Our reference: ECM Ref: 9811393
Contact: Kathryn Saunders
Telephone: (02) 4732 8567

22 December 2021

Request for Advice - EIS - Kemps Creek Data Centre SSD-10101987 at No. 707 – 769 Mamre Road Kemps Creek

PERSPECTIVE VIEW 02 - AERIAL VIEW FROM SOUTH WEST

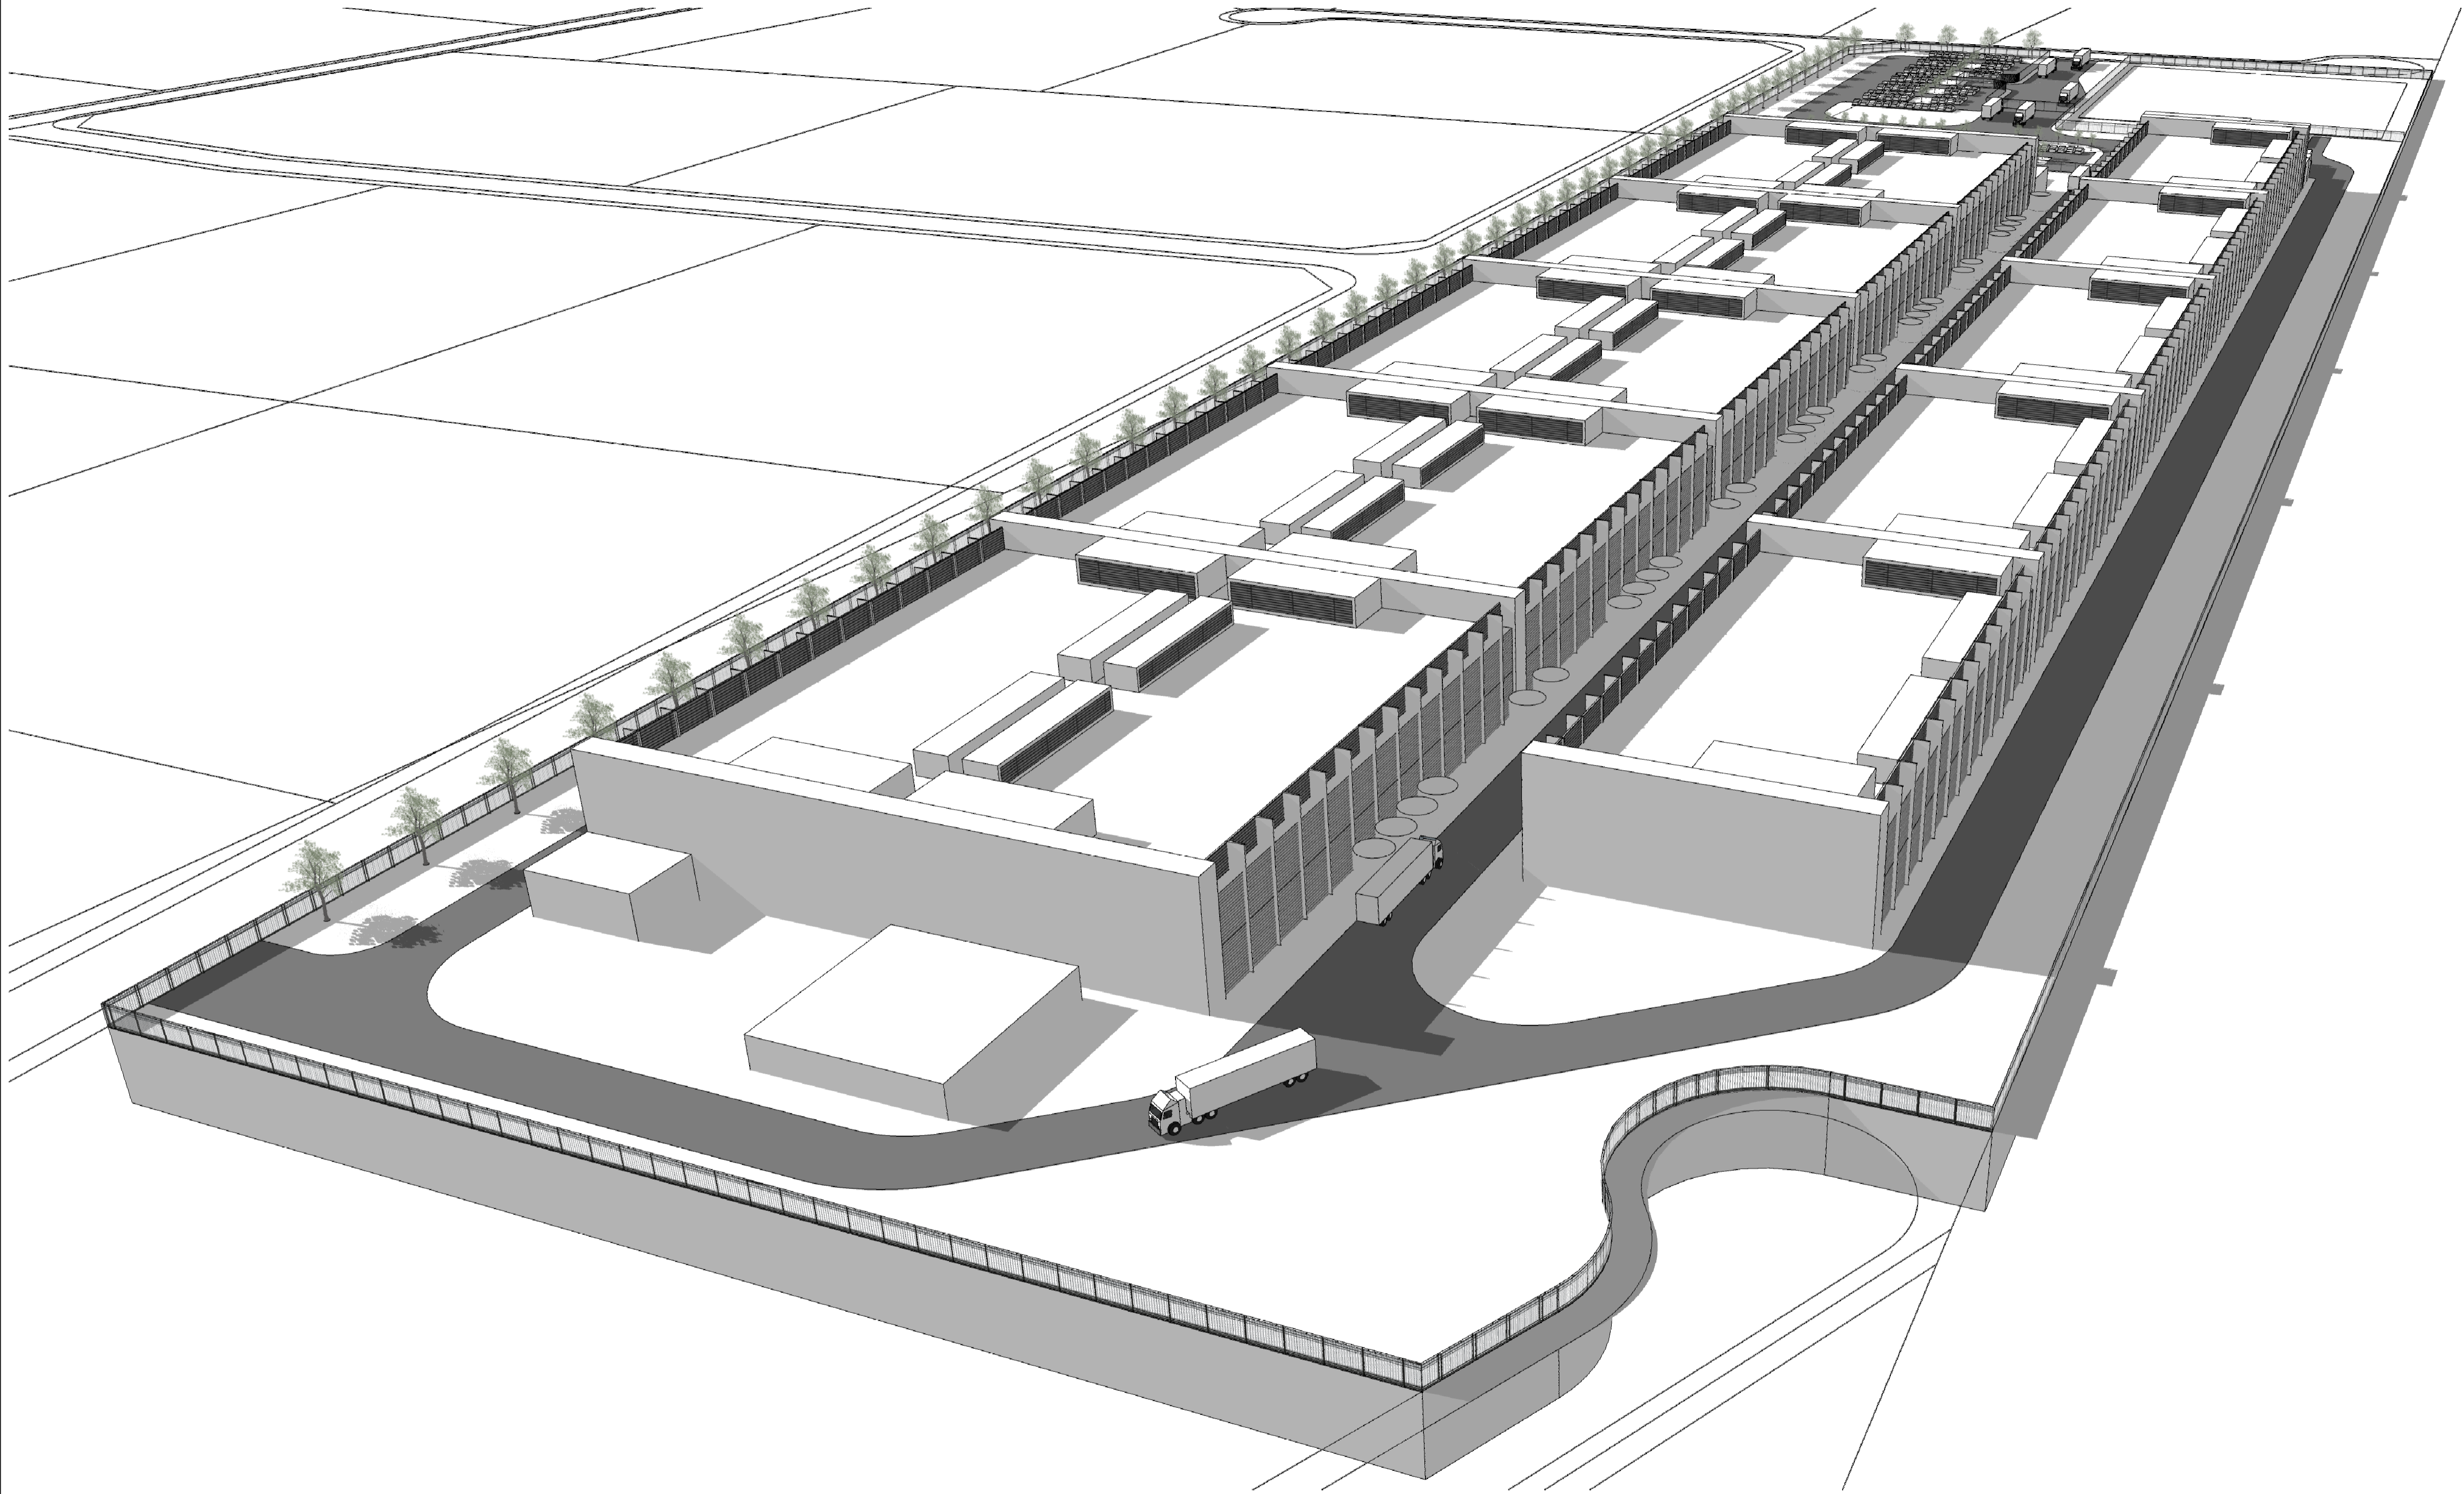
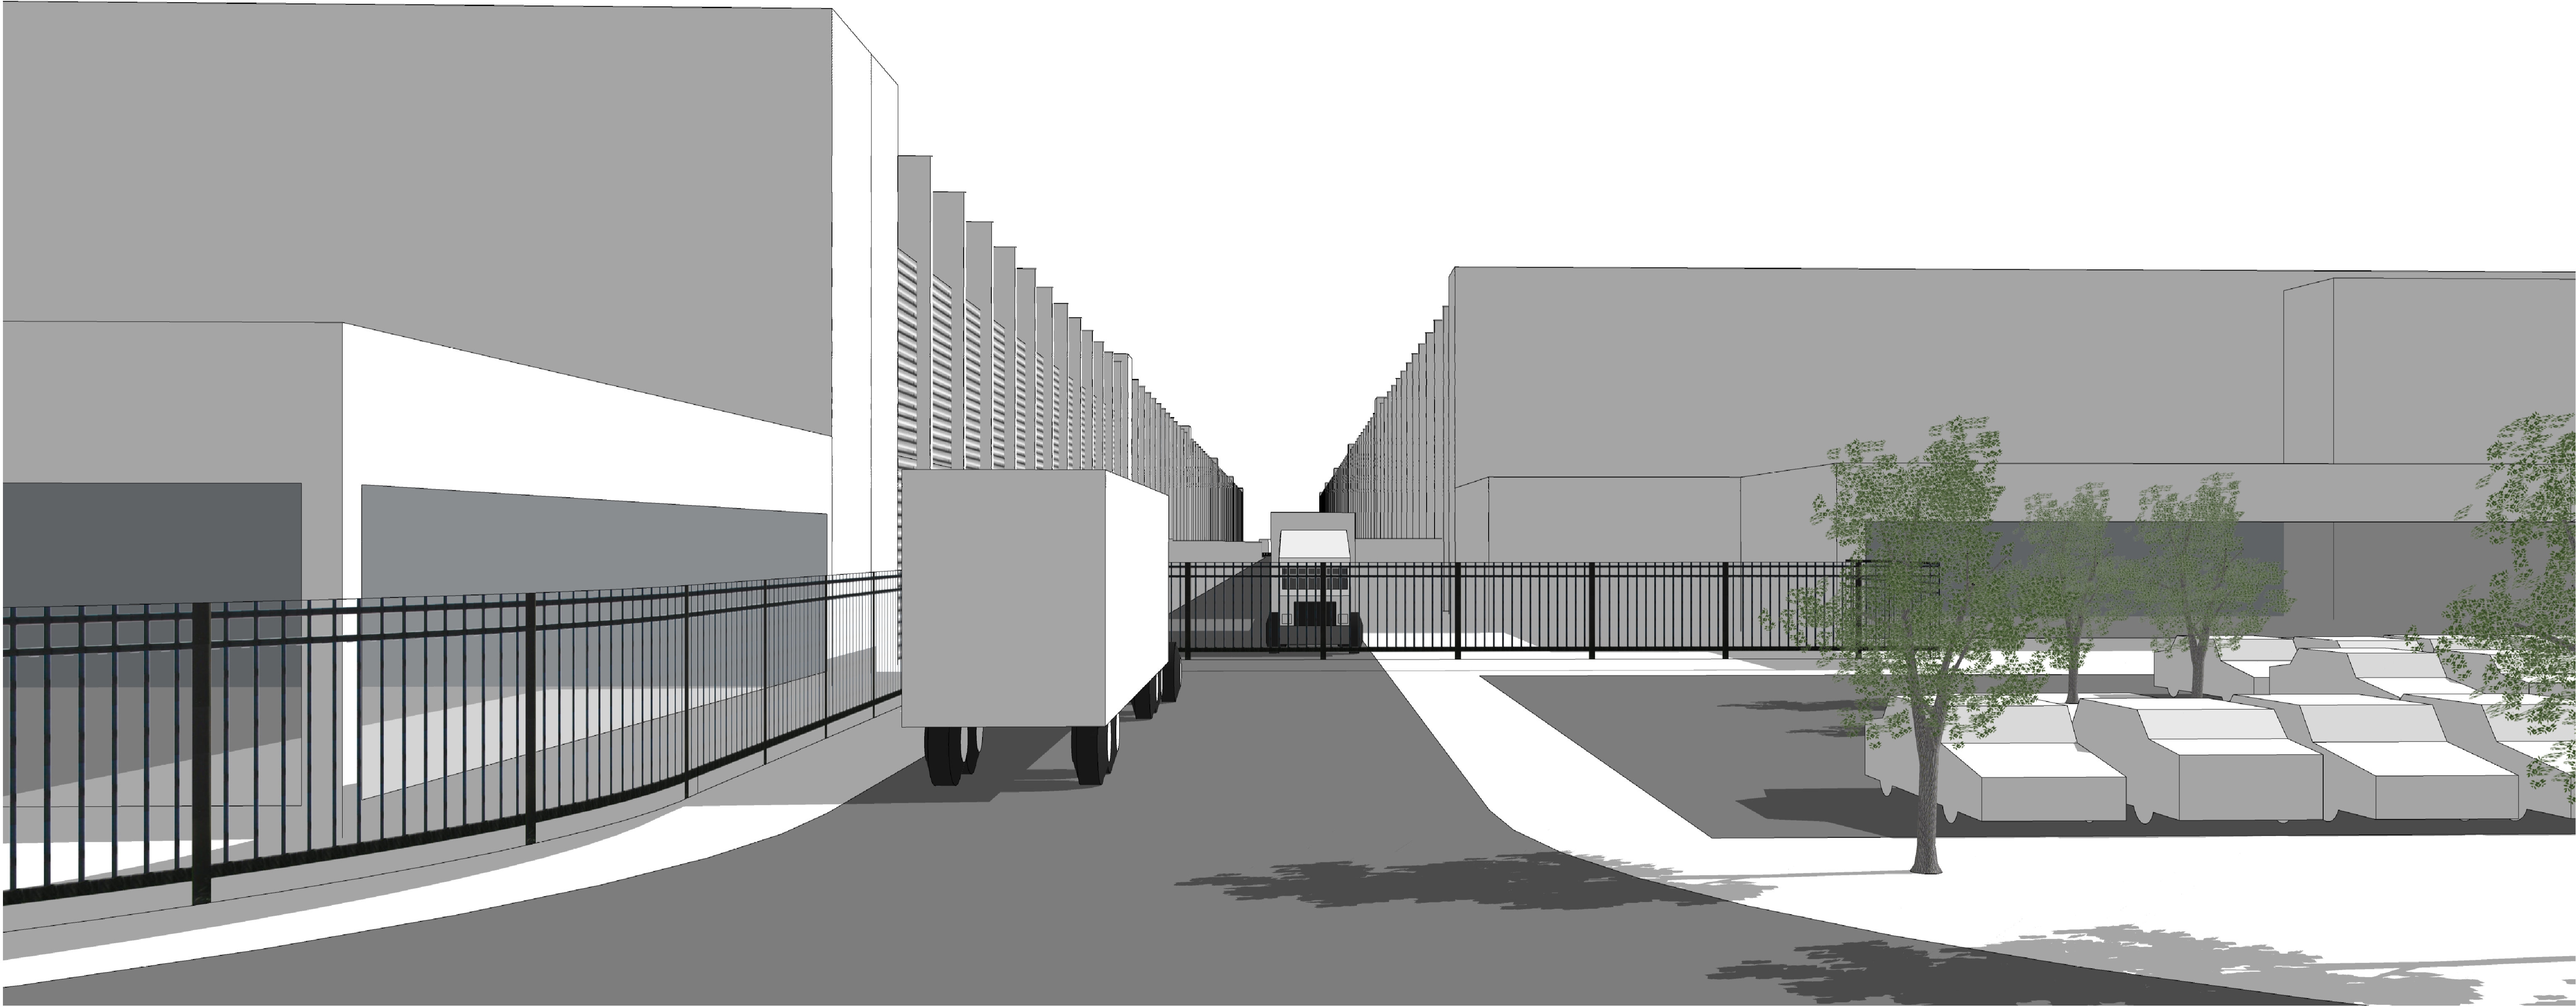
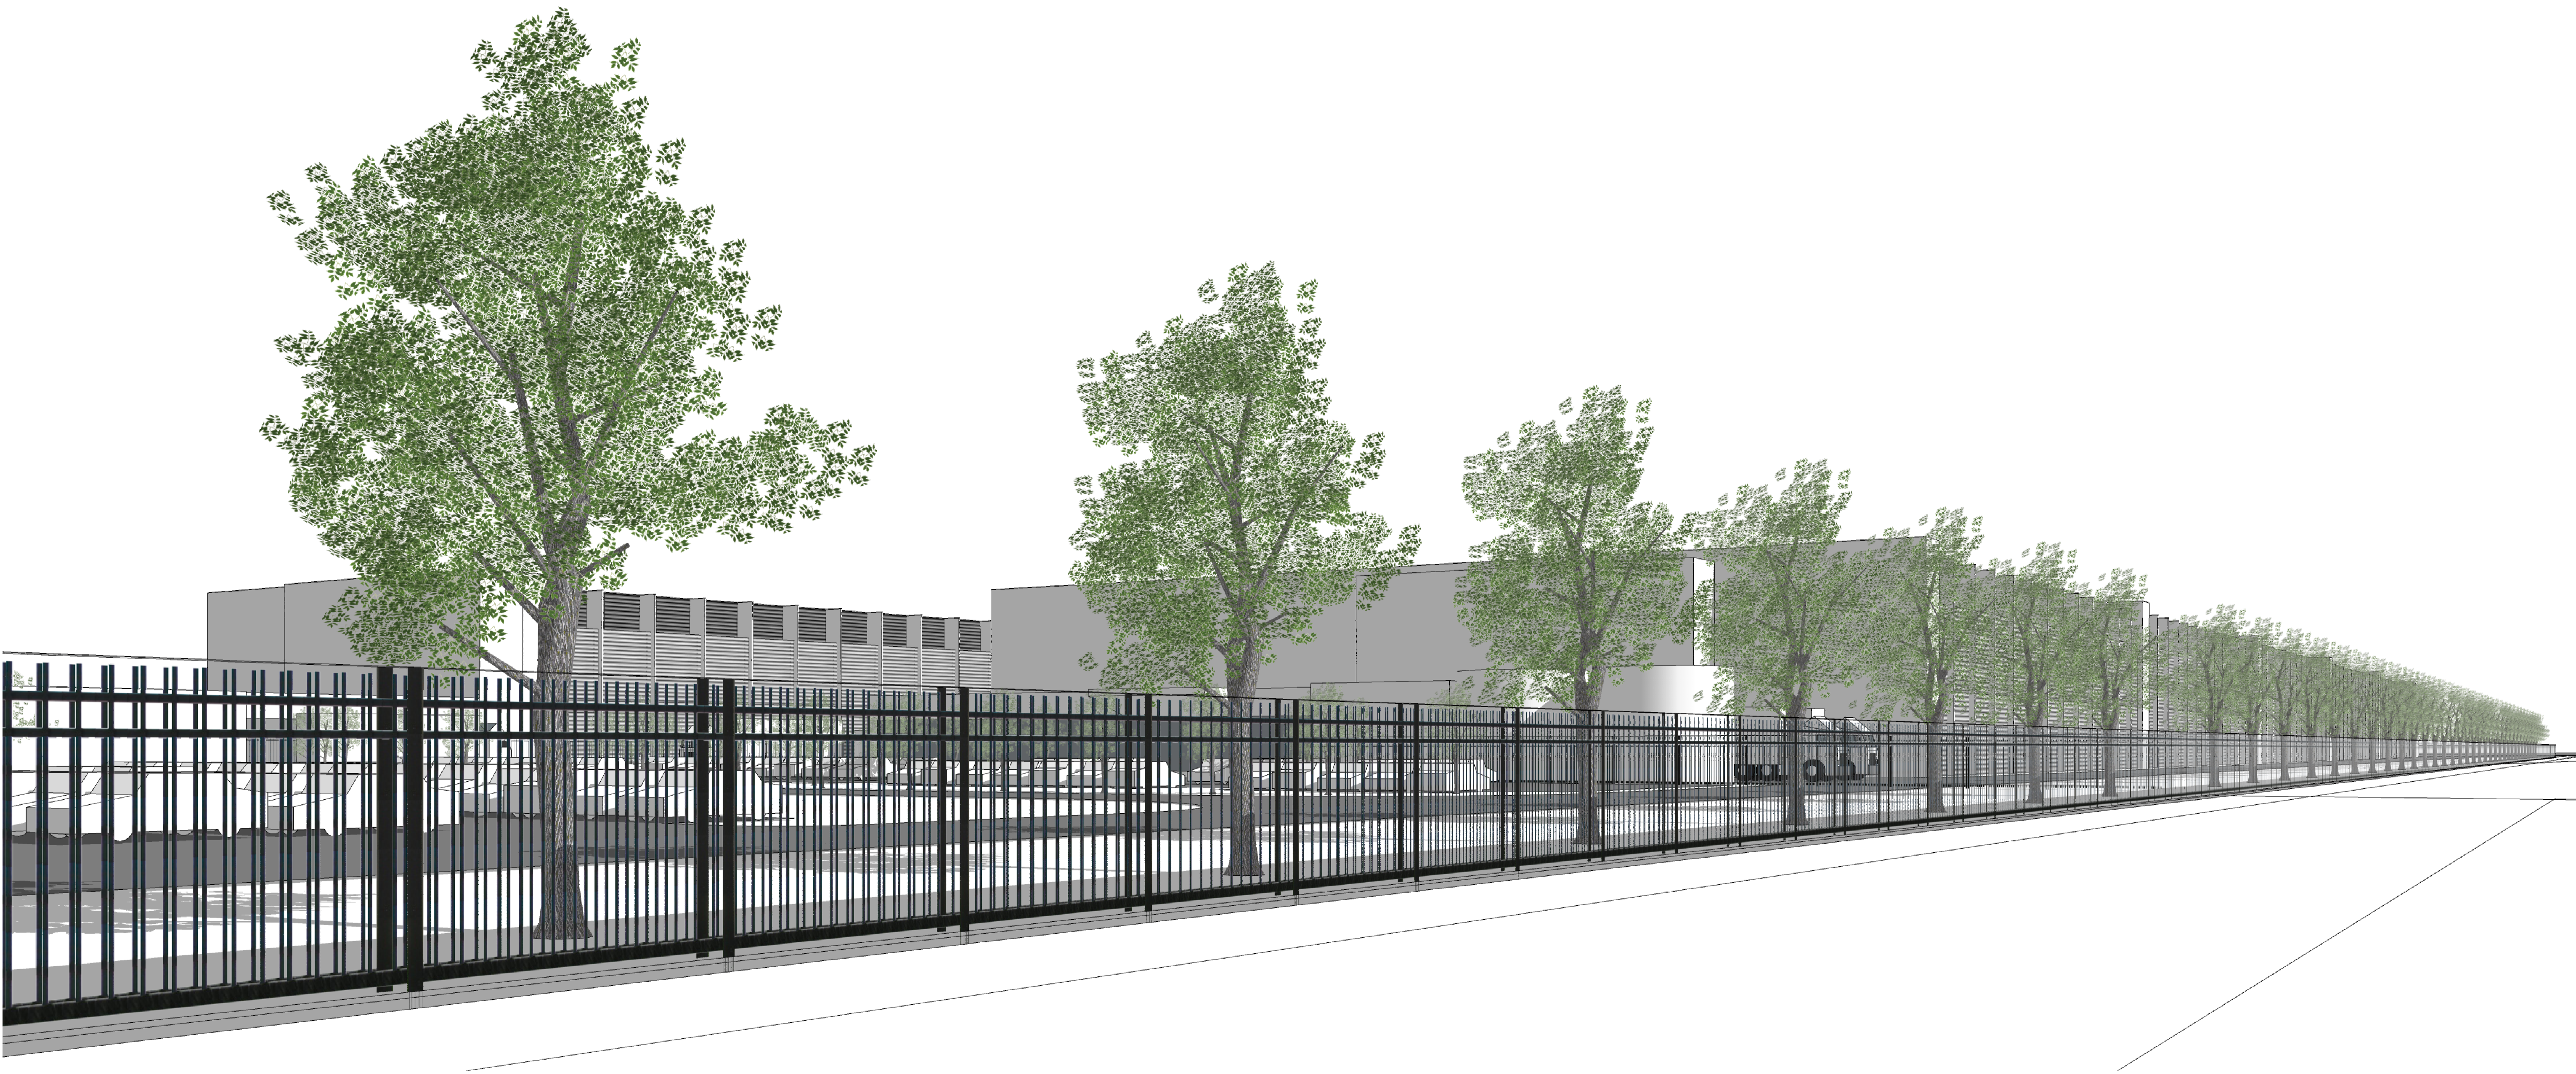
- The perspectives confirm that services including storage tanks substations, plant machinery, external fire stairs and roof and wall mounted plant machinery are not sufficiently moderated through either landscaped design and mounding, through setbacks, or through design responses including services integration, orientation and location.

Therefore it is recommended that DPIE require greater levels of landscape screening around the development to ensure that the data centre and its plant machinery and services infrastructure are not highly visible and dominant in the public domain.
